3. **Project# 1007798**
12DRB-70108 EPC APPROVED SDP
FOR SUBDIVISION 
- CONSENSUS PLANNING agent(s) for CITY OF ALBUQUERQUE/AMAFCA request(s) the above action(s) for all or a portion of Tract(s) A, Z, **VENTANA RANCH COMMUNITY PARK**, zoned R-LT, located on UNIVERS BETWEEN PARADISE AND VENTANA containing approximately 72.6 acre(s). (B-10) *[Deferred from 4/4/12]* **THE SITE PLAN FOR SUBDIVISION WAS APPROVED WITH DELEGATION TO CITY ENGINEER AND TO PLANNING.**

DEVELOPMENT REVIEW BOARD – SPEED MEMO

DRB CASE NO: 1007798

SDP For Subdivision

### MASTER DEVELOPMENT PLAN SITE PLAN

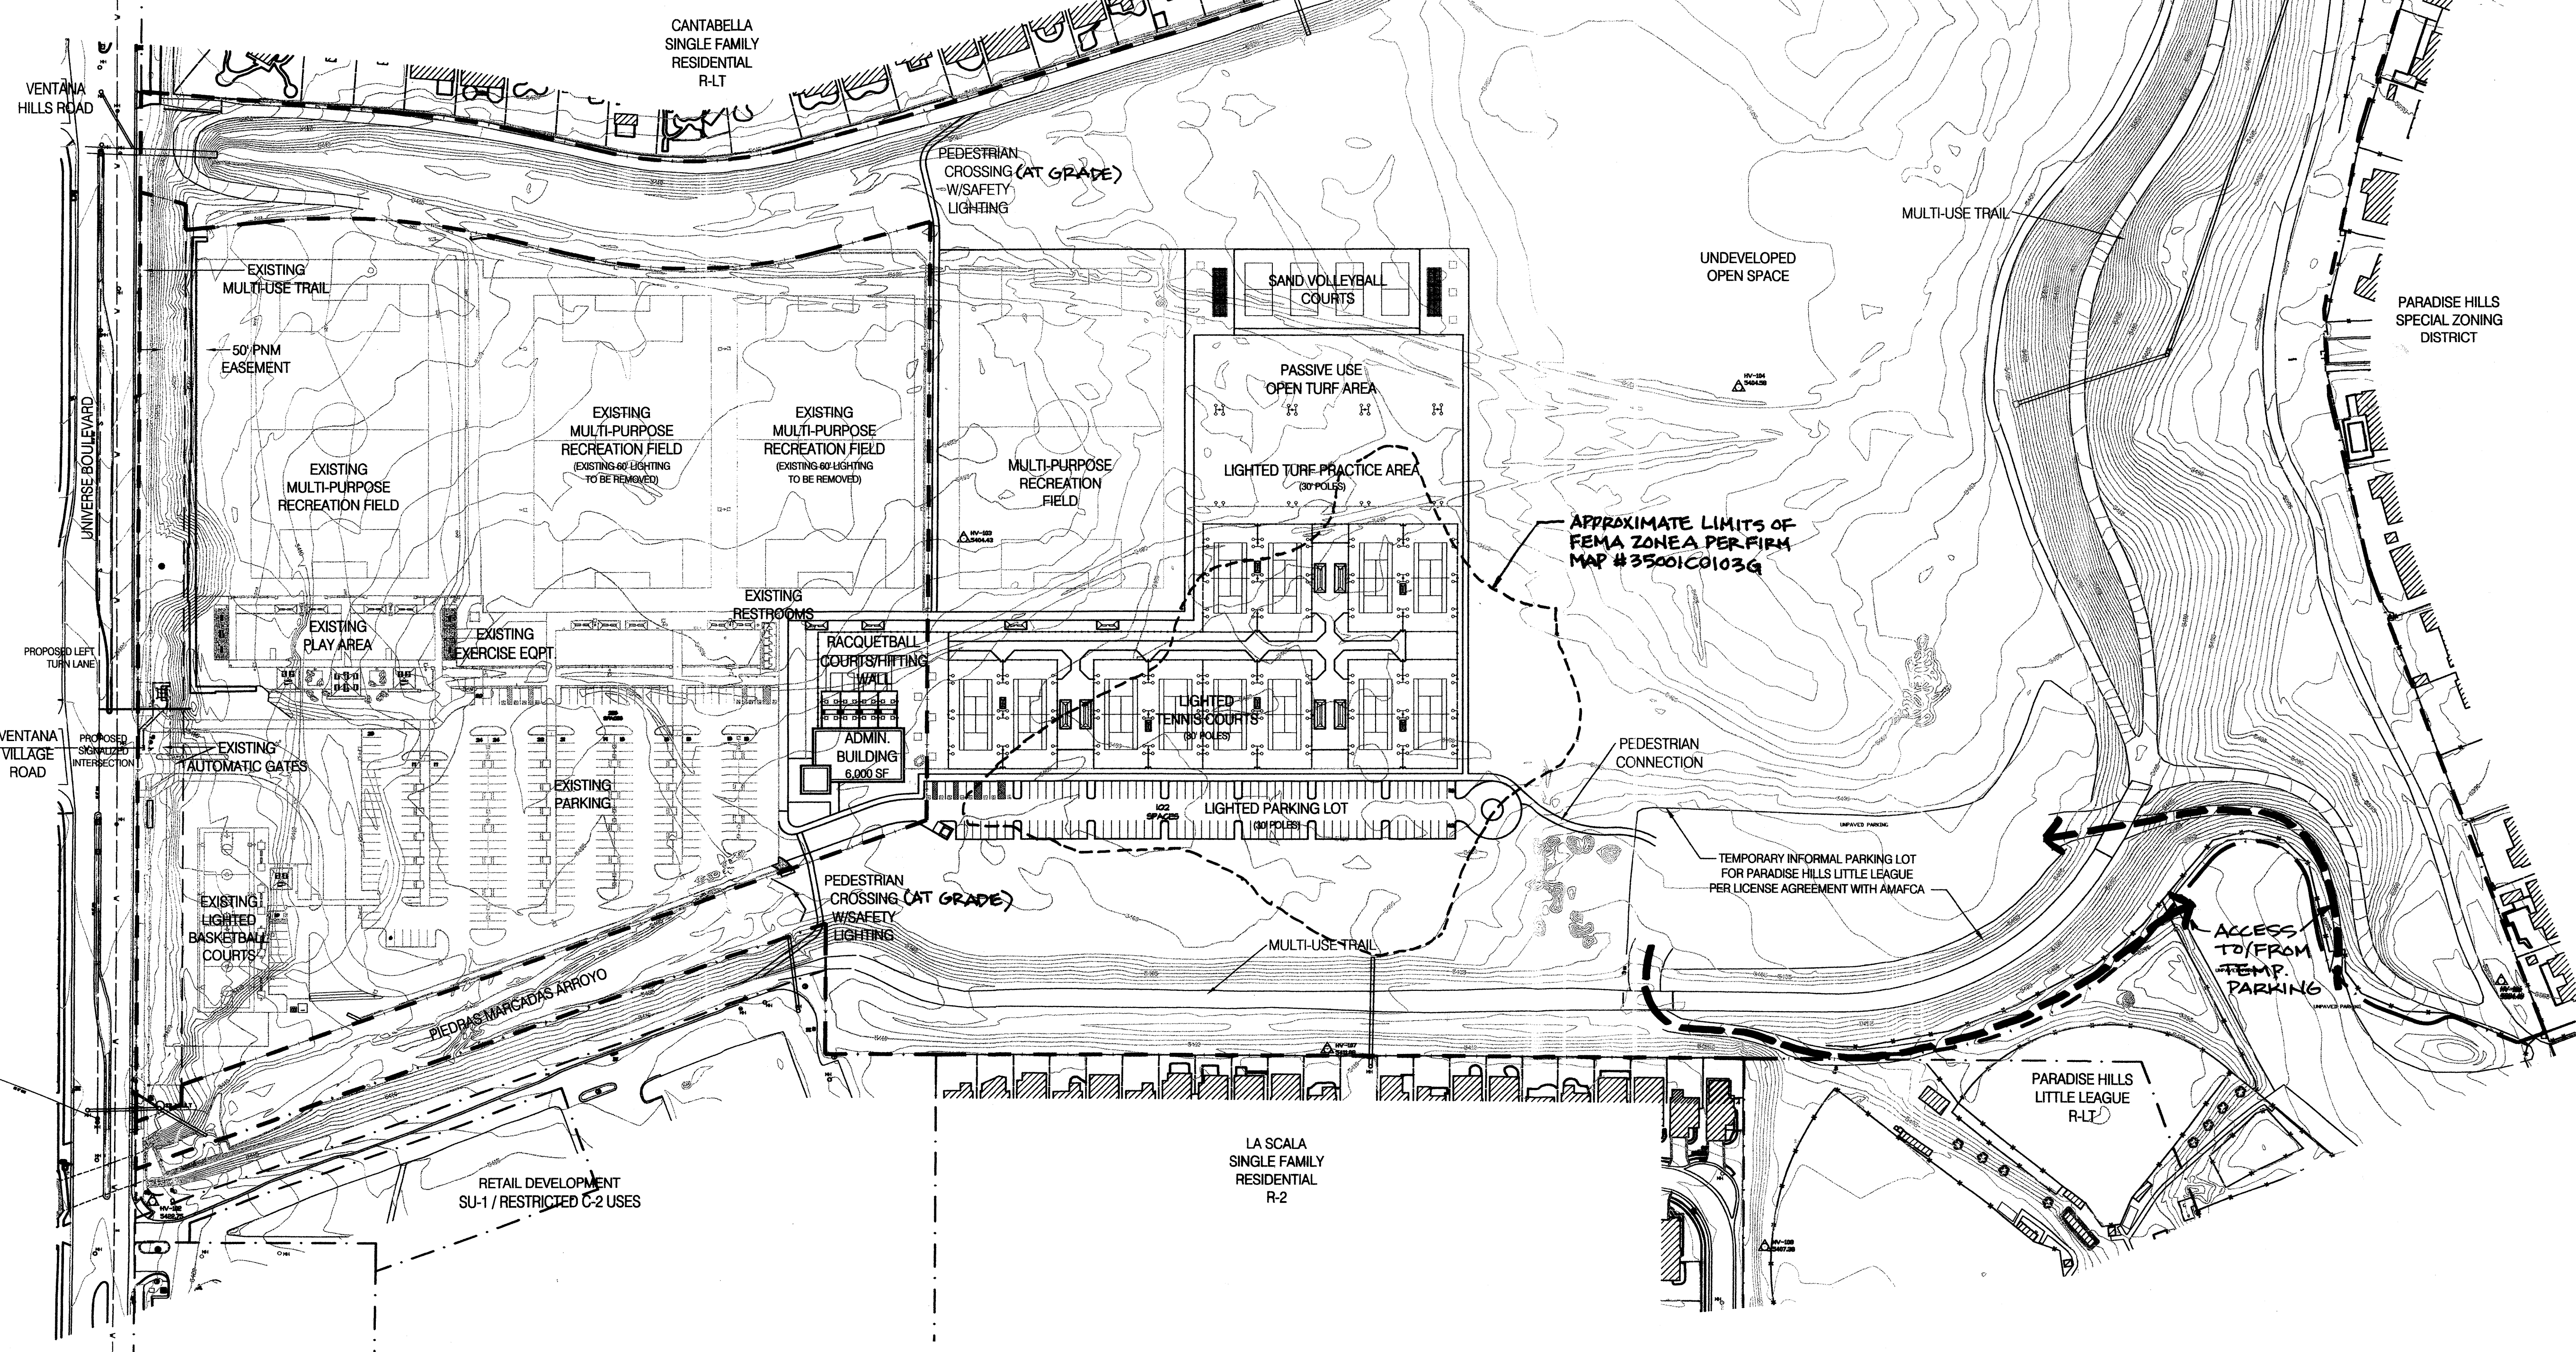
Please clarify how vehicles will reach the "temporary informal parking lot."
Two pedestrian crossings are shown across the Piedras Marcadas Arroyo. Please clarify that these will be pedestrian bridges.

Are the pedestrian crossings across the arroyos grade separated? What do they look like?

PLAT OF  
**TRACT A**  
**VENTANA RANCH COMMUNITY PARK**

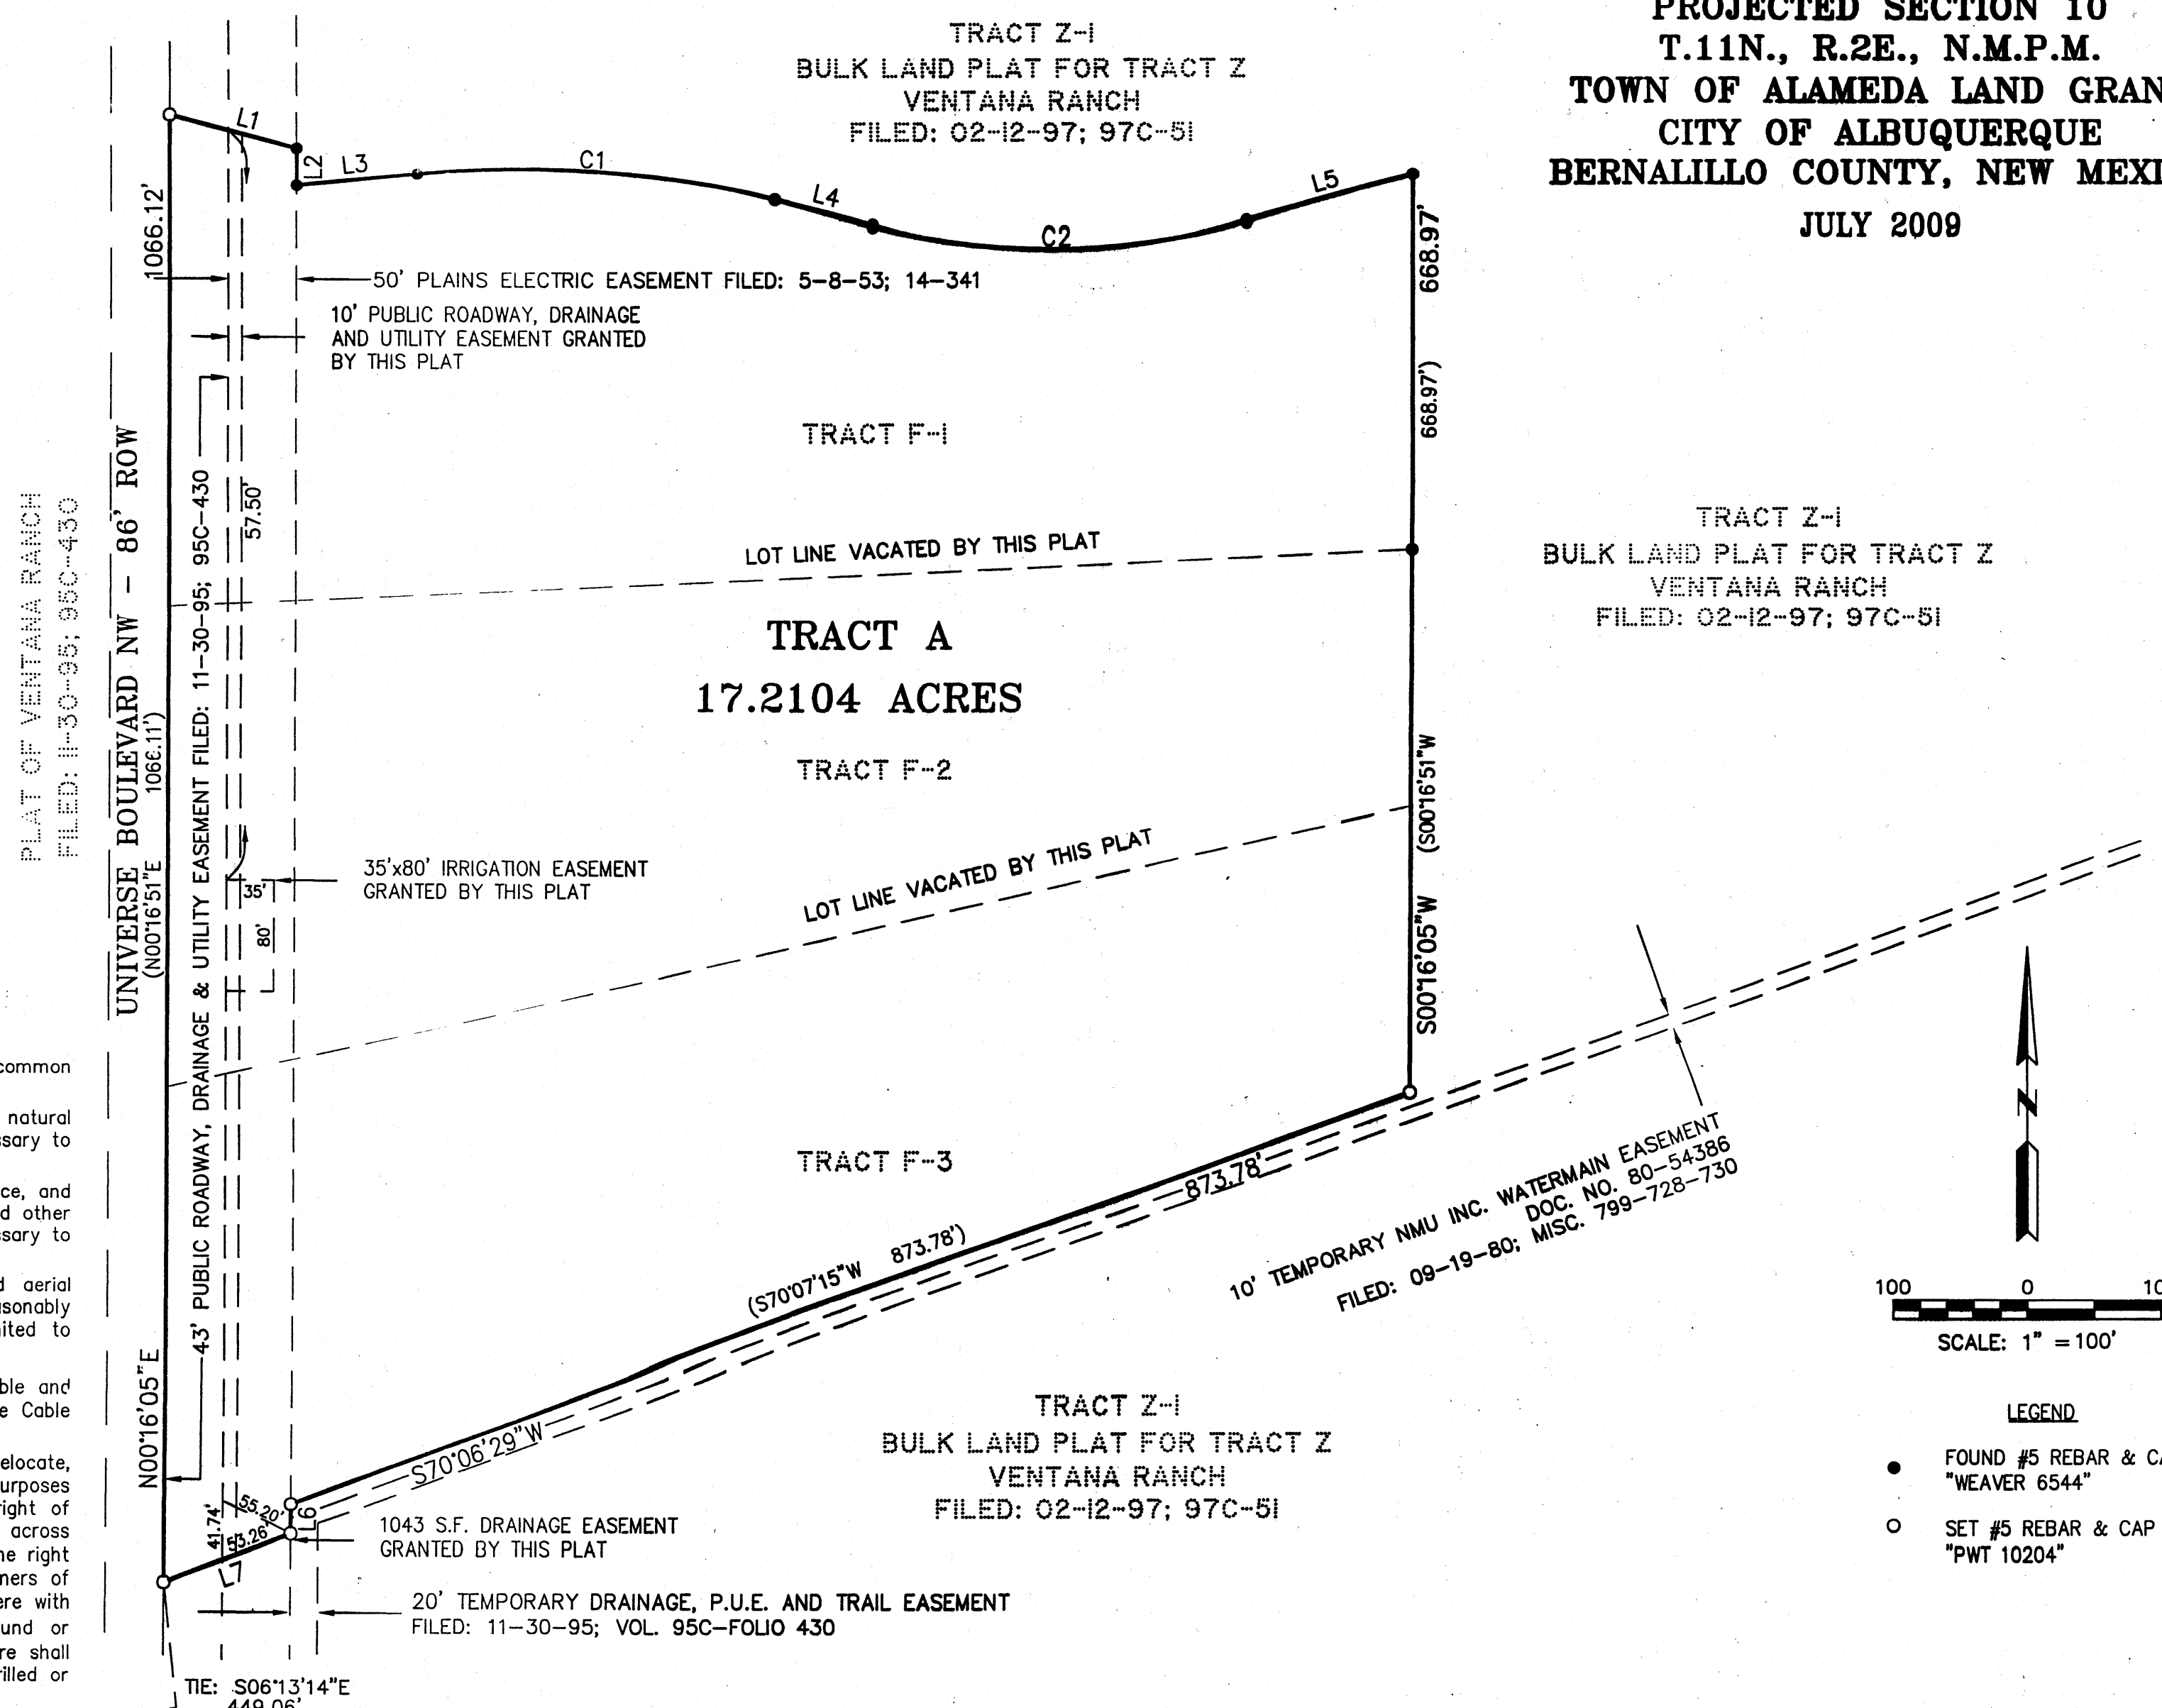
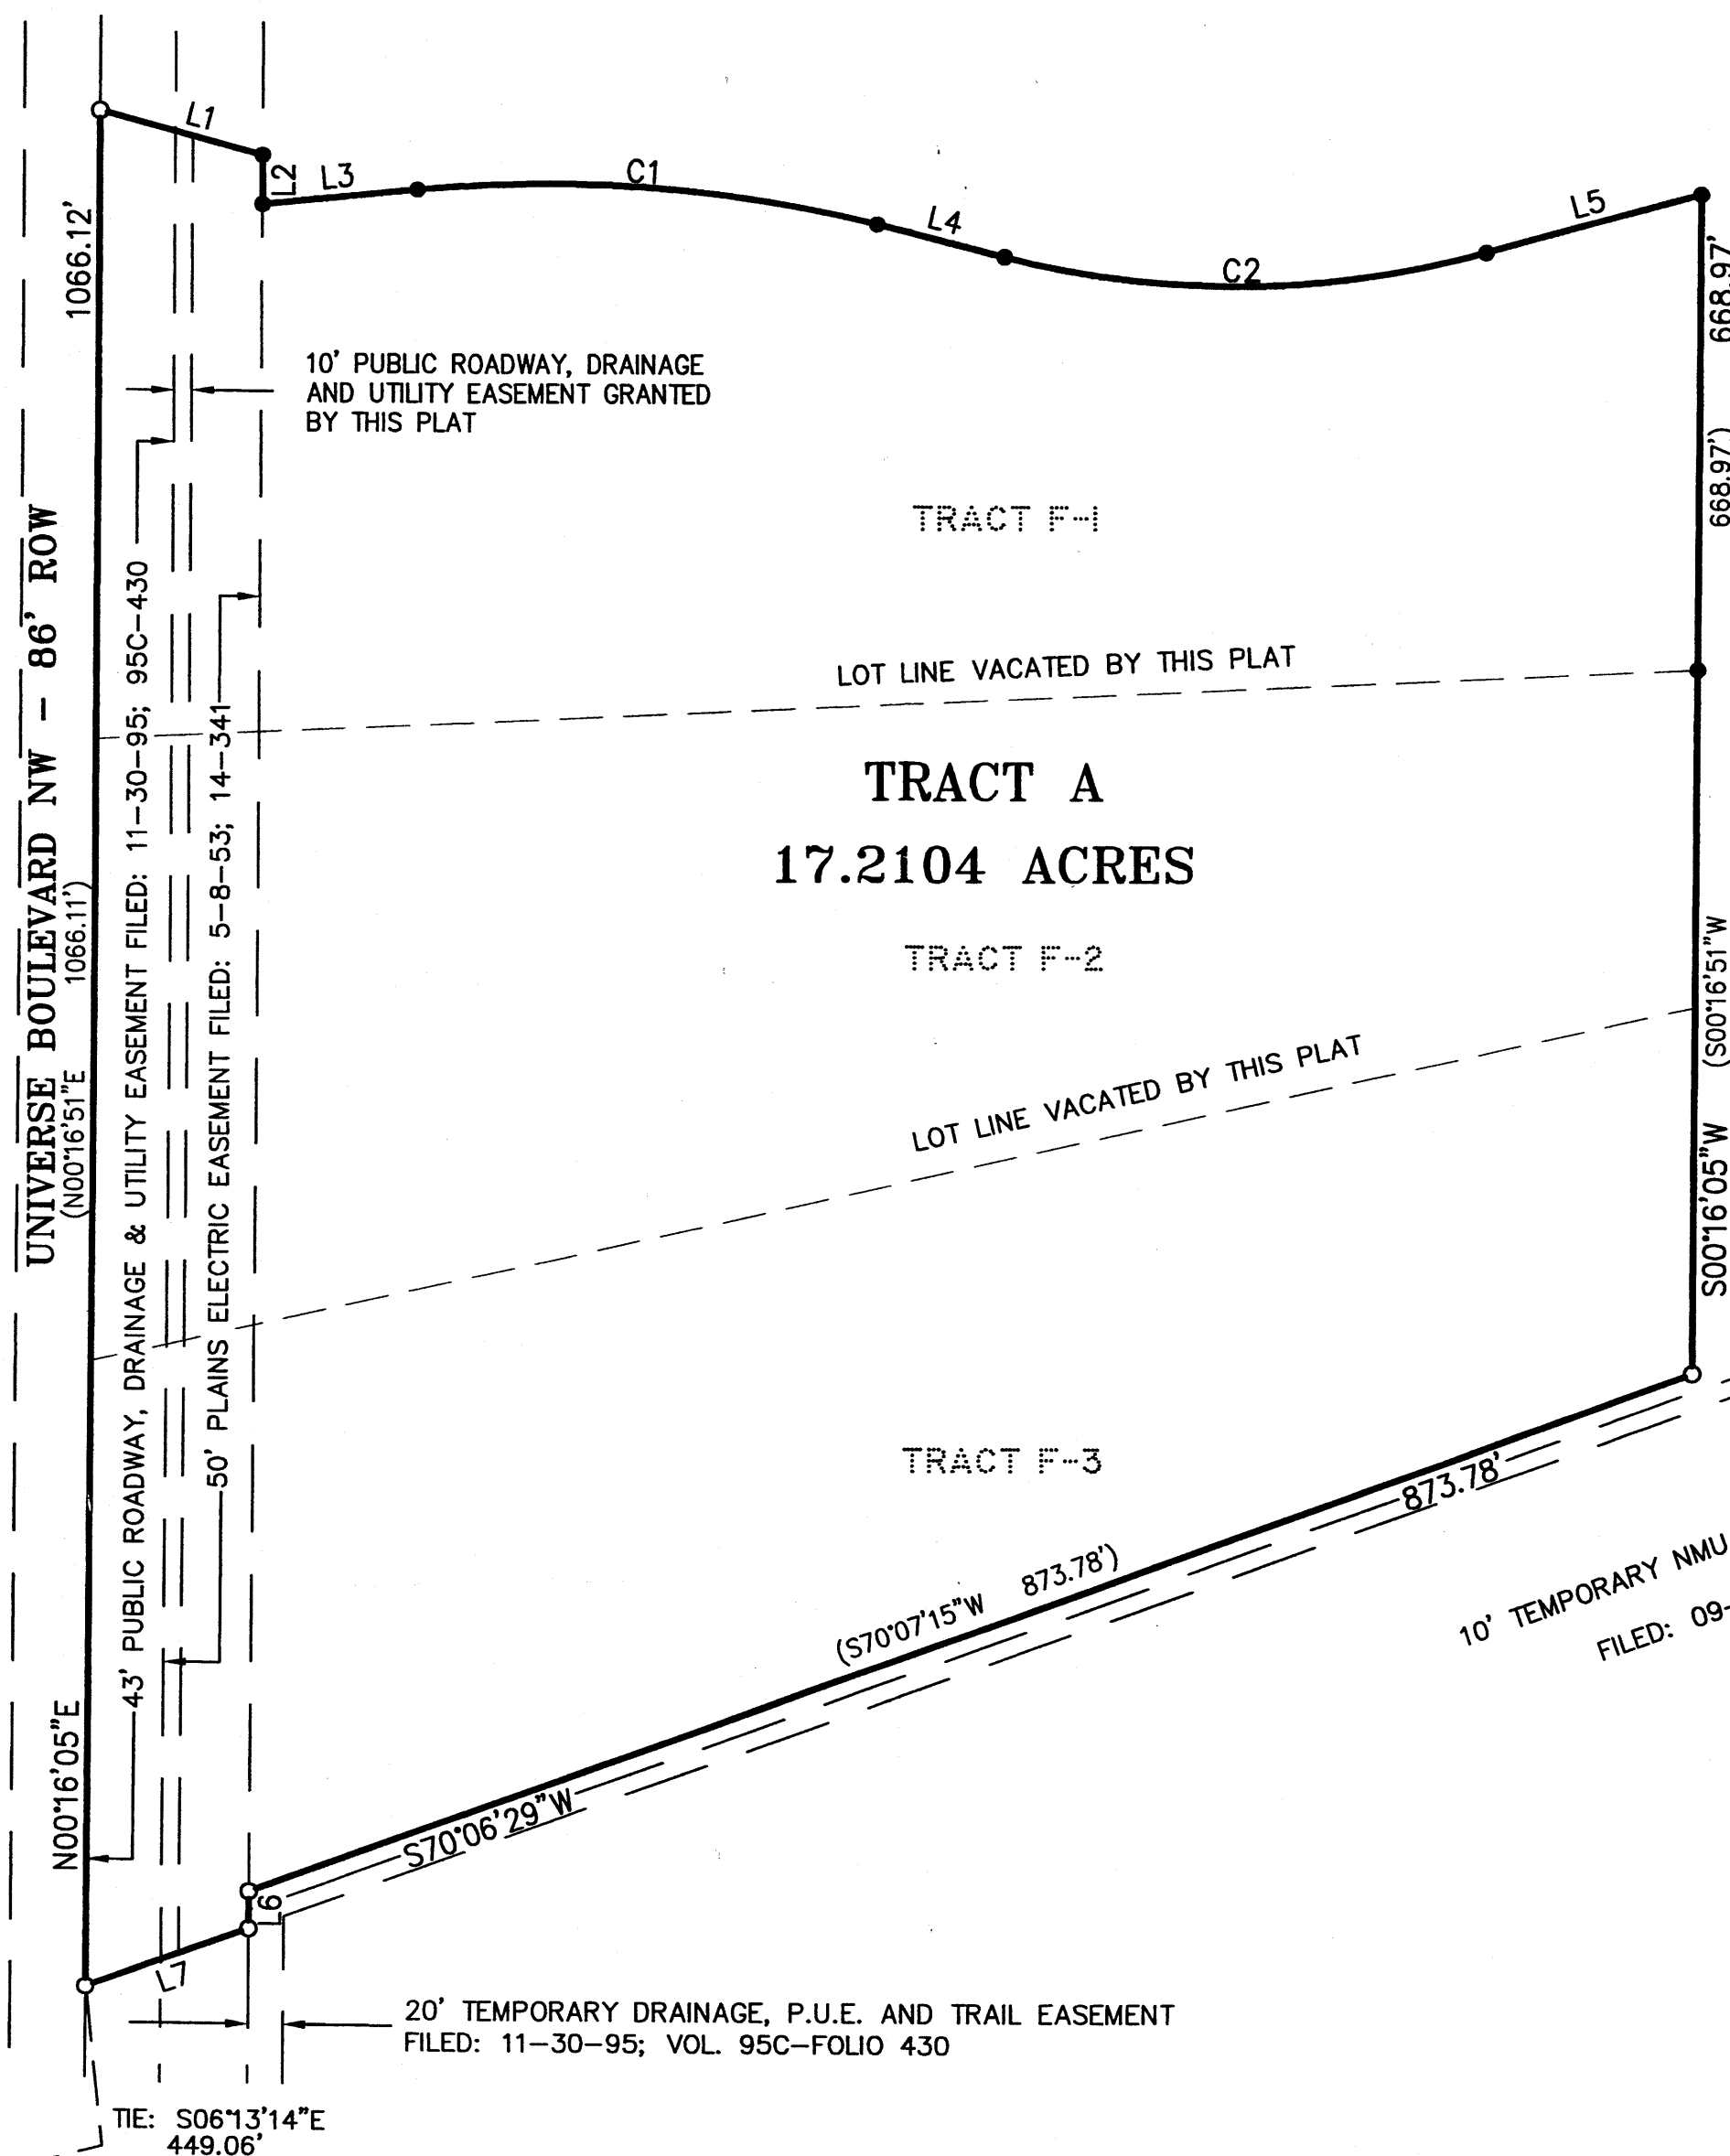
Line Data Table needs to be included on plat.

A Solar Note will be needed on the plat (consistent with Section 14-14-4-7 of the Subdivision Ordinance) which is specific to this type of request, i.e. use the words "THIS PLAT" (rather than the words "REQUESTED FINAL ACTION") at the beginning of the note, and do not use the words "OR SITE DEVELOPMENT PLAN FOR SUBDIVISION" at the end of the note. Also, please delete the Zoning Note (Data #7, Notes # 5) from the plat.

Need storm drain easement.
AMAFCA must sign plat.
